M5 Junction 10 Improvements Scheme

Combined Change log for Statement of Reasons,
Book of Reference, Land Plans and Crown Land
Plans

TR010063 - APP 9.22

Volume 9
October 2024

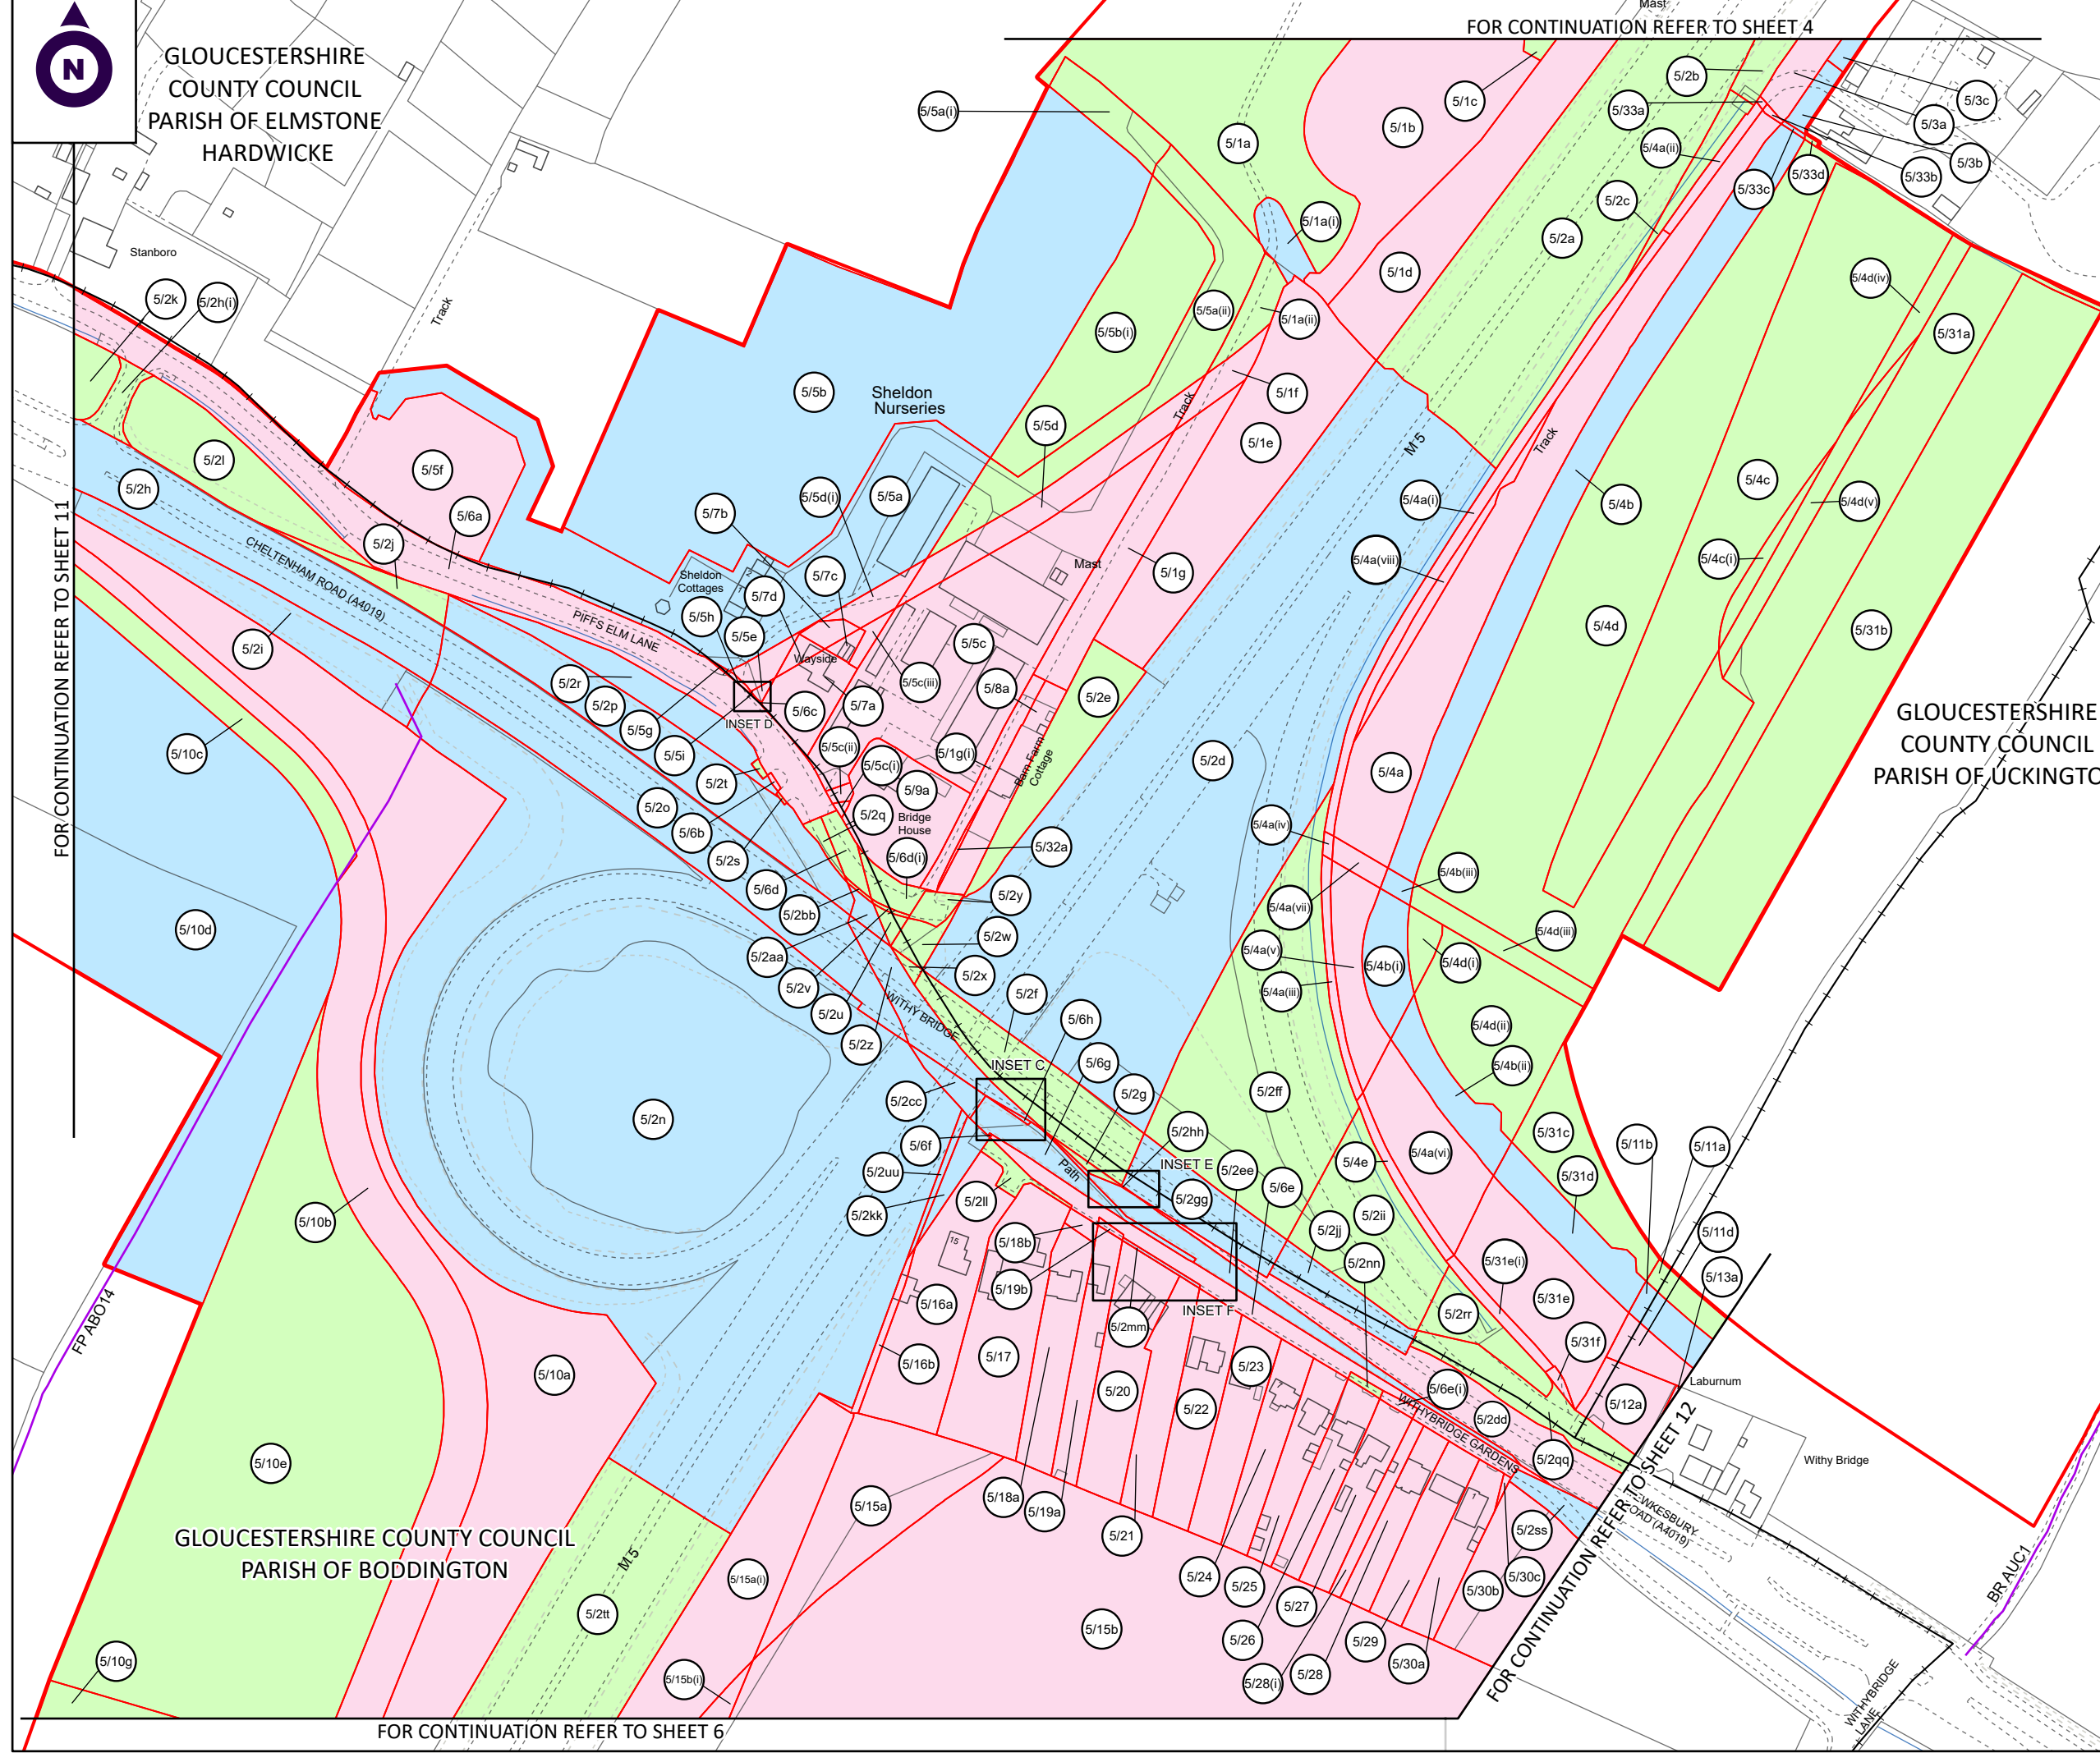
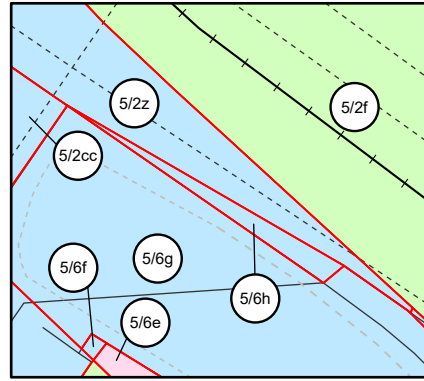
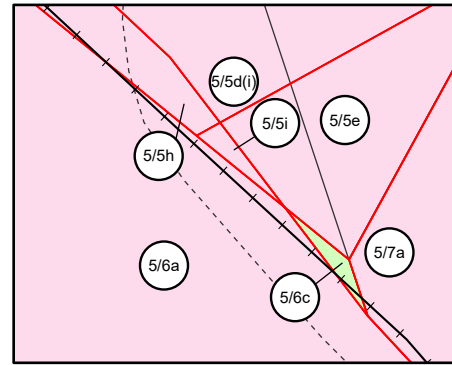
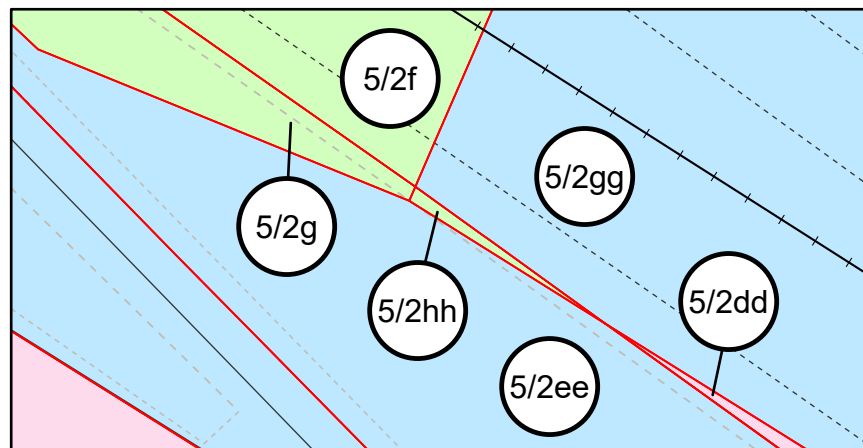
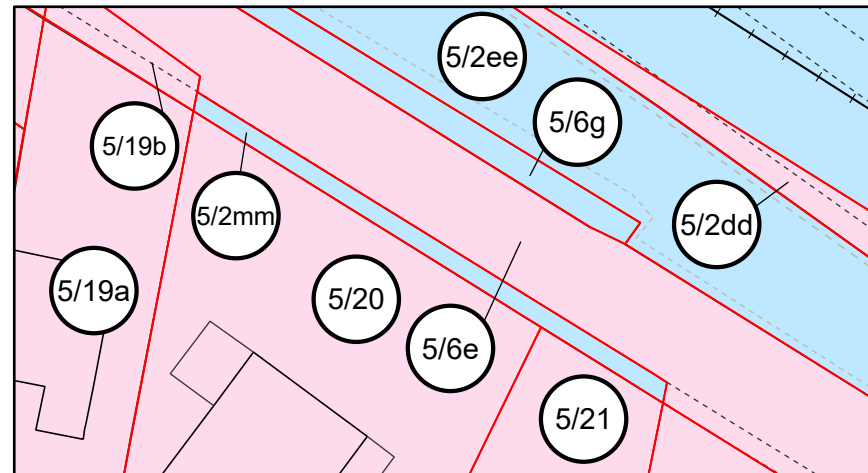
6	4/1c	BoR	Plot downgraded from permanent acquisition to rights/temporary only
7	4/1c(i)	Land Plan Sheet 4	Plot downgraded from acquisition (pink) to temporary (green)
8	4/1c(i)	SoR	Plot downgraded from permanent acquisition to temporary only with works no 1a 'Required for the construction of motorway signage and associated cabling and ducting works'
9	4/1c(i)	BoR	Plot downgraded from permanent acquisition to temporary only
10	5/2z	Land Plan Sheet 5	Plot downgraded from acquisition (pink) to rights/temporary (blue)
11	5/2z	SoR	Plot downgraded from permanent acquisition to rights/temporary only with works no 2 'New right for the construction of a new grade separated roundabout junction and maintenance bays' and 2d 'New right for the demolition of the existing A4019 bridge over the M5'
12	5/2z	BoR	Plot downgraded from permanent acquisition to rights/temporary only
13	5/6h	Land Plan Sheet 5	Plot downgraded from acquisition (pink) to rights/temporary (blue)

14	5/6h	SoR	Plot downgraded from permanent acquisition to rights/temporary only with works no 2 'New right for the construction of a new grade separated roundabout junction and maintenance bays' and 2d 'New right for the demolition of the existing A4019 bridge over the M5'
15	5/6h	BoR	Plot downgraded from permanent acquisition to rights/temporary only
16	13/3r	SoR	Additional works number added to plot, work no 4n 'Required for the construction of a service road running east and west of The Green'
17	15/3c	SoR	Additional works number added to plot, work no 5e 'New right for the diversion, construction, use and maintenance of public right of way FP AUC11 to the north of the River Chelt under the new River Chelt Bridge'
18	4/1c, 5/2z, 5/6h	SoR	National Highways Limited - Plot moved from (a) Permanent to (c) Rights and Temporary
19	4/1c(i)	SoR	National Highways Limited - Plot moved from (a) Permanent to (b) Temporary

20	3/2c	SoR	National Highways Limited - Plot moved from (c) Rights and Temporary to (b) Temporary
21	4/1c, 5/2z, 5/6h	SoR	Gloucestershire County Council - Plot moved from (a) Permanent to (c) Rights and Temporary
22	4/1c(i)	SoR	Gloucestershire County Council - Plot moved from (a) Permanent to (b) Temporary
23	3/2c	SoR	Michael Sidney Kennedy - Plot moved from (c) Rights and Temporary to (b) Temporary
24	3/2c	SoR	Susan Denise Kennedy - Plot moved from (c) Rights and Temporary to (b) Temporary
25	4/1c(i)	SoR	Gigaclear Limited - Plot moved from (a) Permanent to (b) Temporary
26	4/1c(i)	SoR	Severn Trent Water Limited - Plot moved from (a) Permanent to (b) Temporary
27	5/2z	SoR	British Telecommunications plc - Plot moved from (a) Permanent to (c) Rights and Temporary
28	5/2z	SoR	Openreach Limited (BT) - Plot moved from (a) Permanent to (c) Rights and Temporary
29	n/a	Land plan sheet 5	removal on insert C and D

30	n/a	Land plans sheet 5 A	new page added, and inserts C and D moved to this page. Inserts E and F added. Note subsequent insets have been relabelled.
